Ribble Valley Borough Council
Housing & Development Control

Application no: **3/2022/1165**

Address: **Lower Reaps Farm Whinney Lane Mellor BB2 7EL**

The Local Highway Authority have viewed the plans and highway related documents and have the following comments to make:

Scale: 1:2500 | Area 36Ha | Grid Reference: 366348,430280 | Paper Size: A3

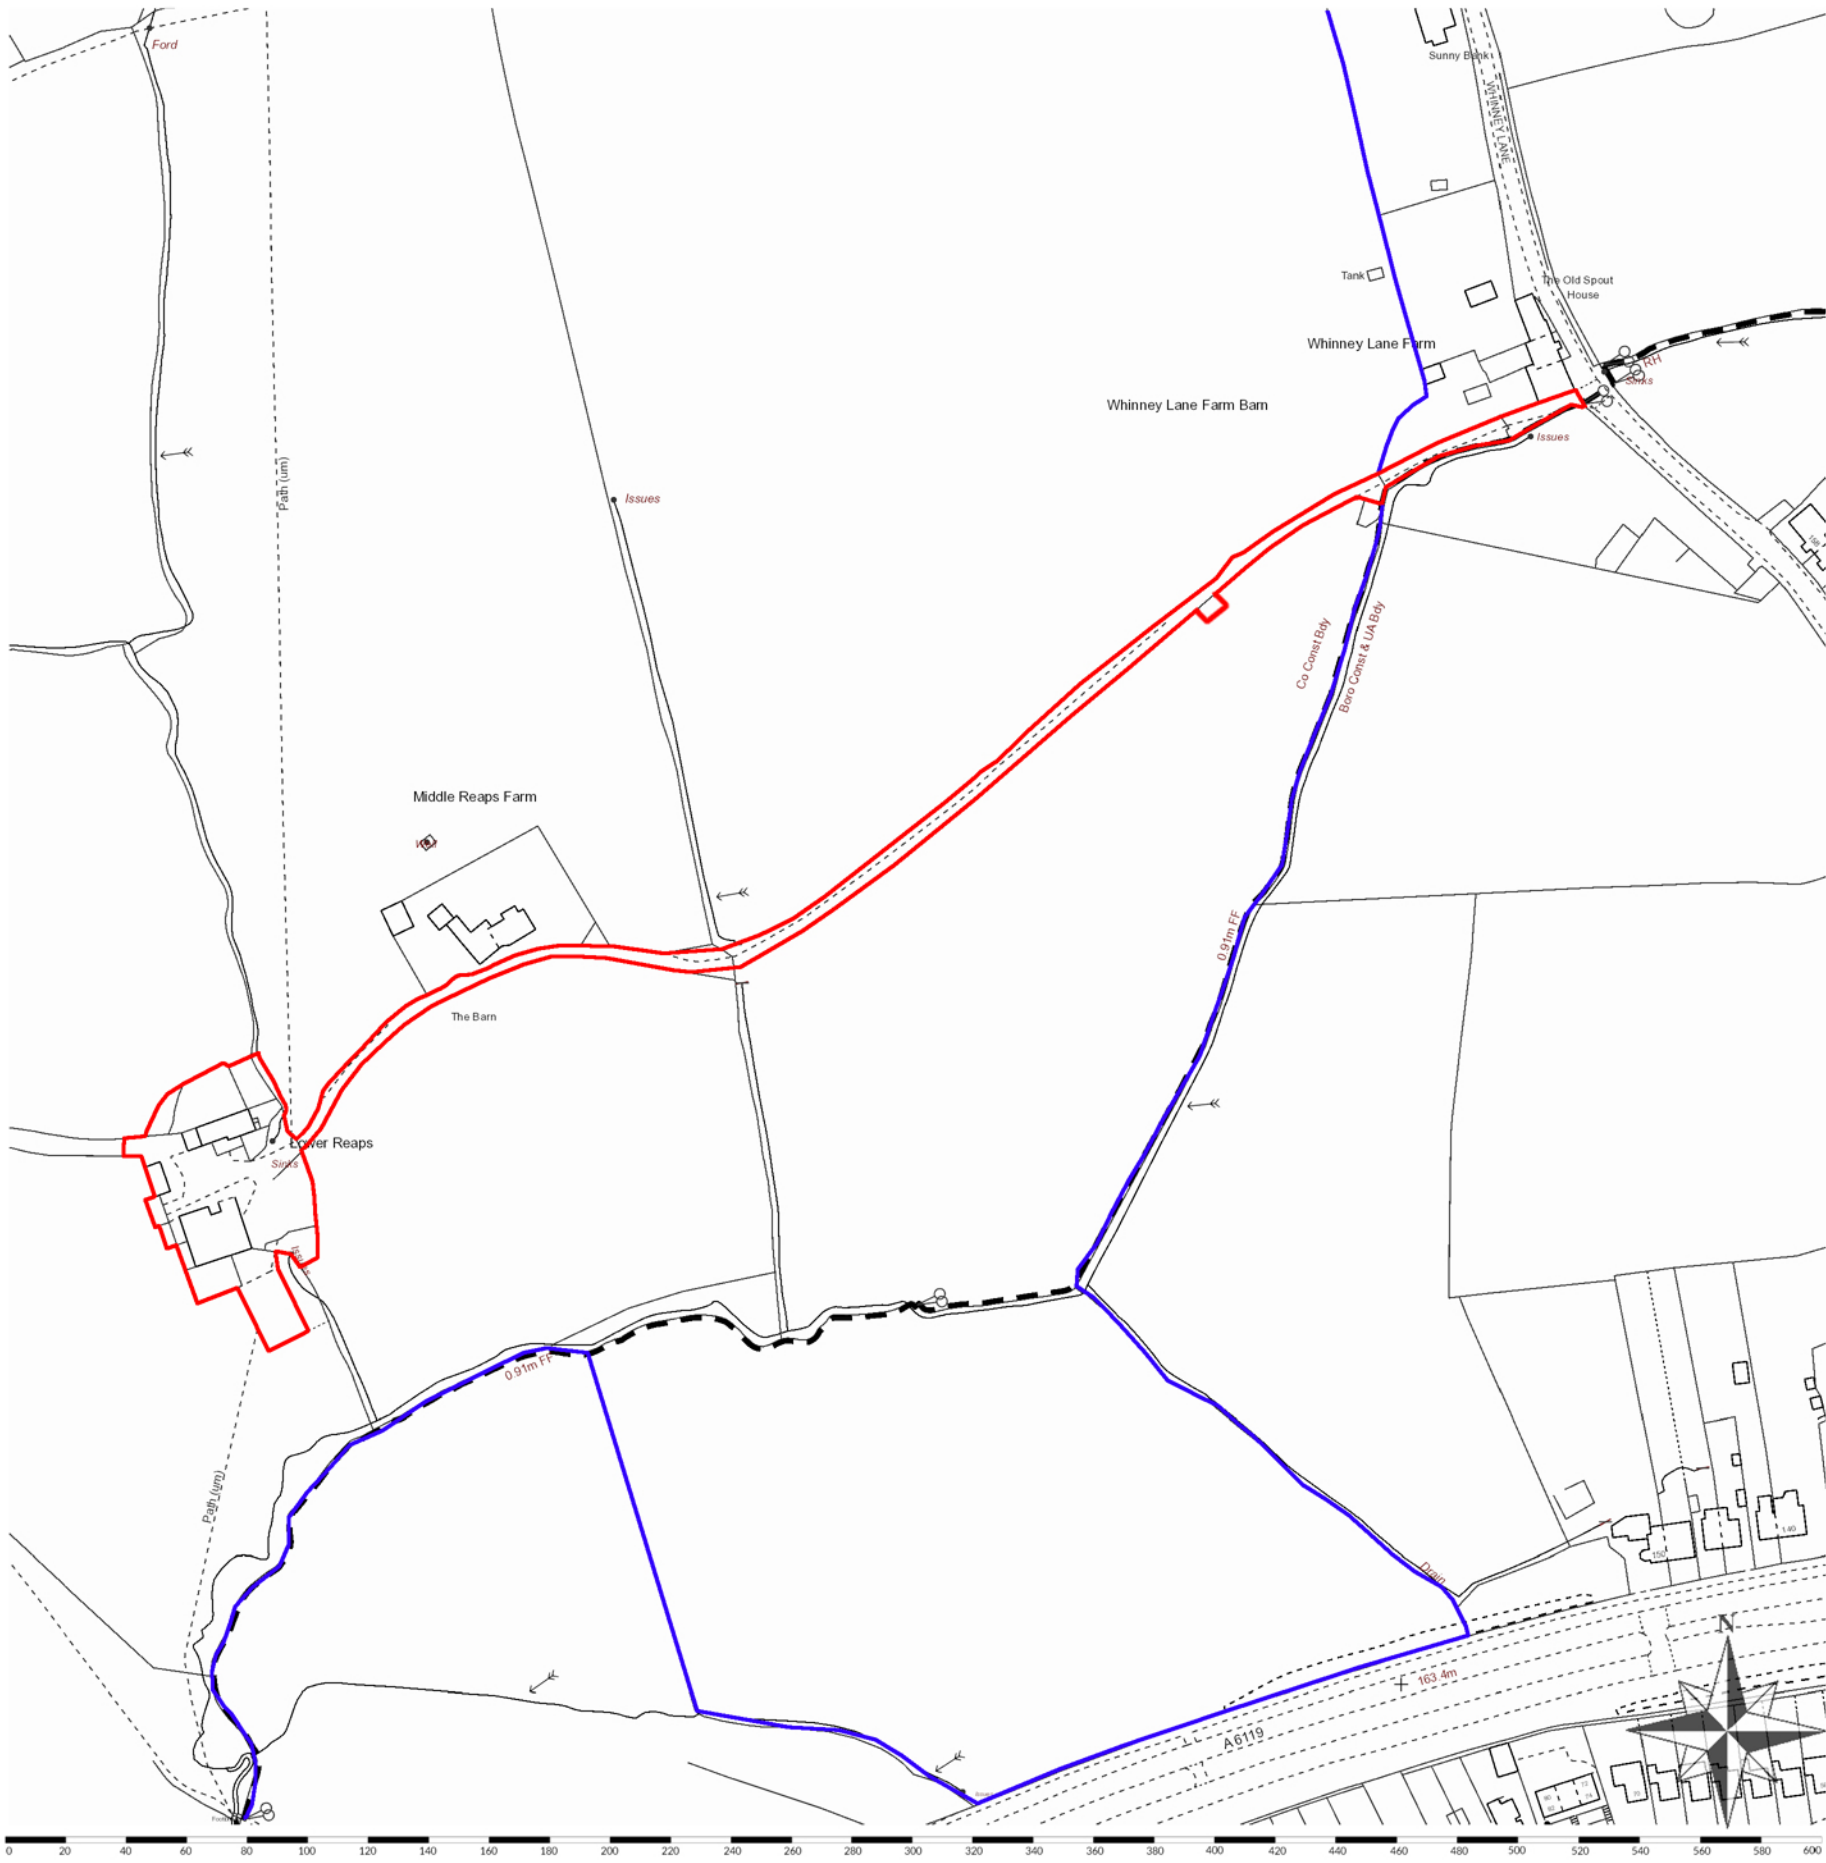
The LHA have reviewed the drawing provided by Groundsure titled "Location Plan" which shows the access located off Whinney Lane and the existing access track into the site and are aware that the access width complies with the LHAs guidance.

However, following the intensification of use of the access following the proposal and the access being located within two speed limits, a 30mph speed limit to the right and a 60mph speed limit to the left of the access, the LHA require a traffic survey to be undertaken demonstrating to the LHA the 85th percentile speeds along Whinney Lane.

The traffic survey should then be complemented with a visibility splay drawing showing that the access can provide the minimum visibility splays for the 85th percentile speeds recorded. The LHA remind the Agent that the setback distance of the visibility splays should be 2.4m from the centreline of the access.

The LHA also require passing places to be provided a minimum of every 200m along the access track to the site. This is because the access track is single tracked in nature meaning that two-way movements are unlikely to be able to occur along the track. The LHA require the passing places to be a minimum of 2m x 15m in length should Middle Reaps Farm still undertake agricultural practices at their site or 2.5m x 5.5m should Middle Reaps Farm have already ceased their agricultural use.
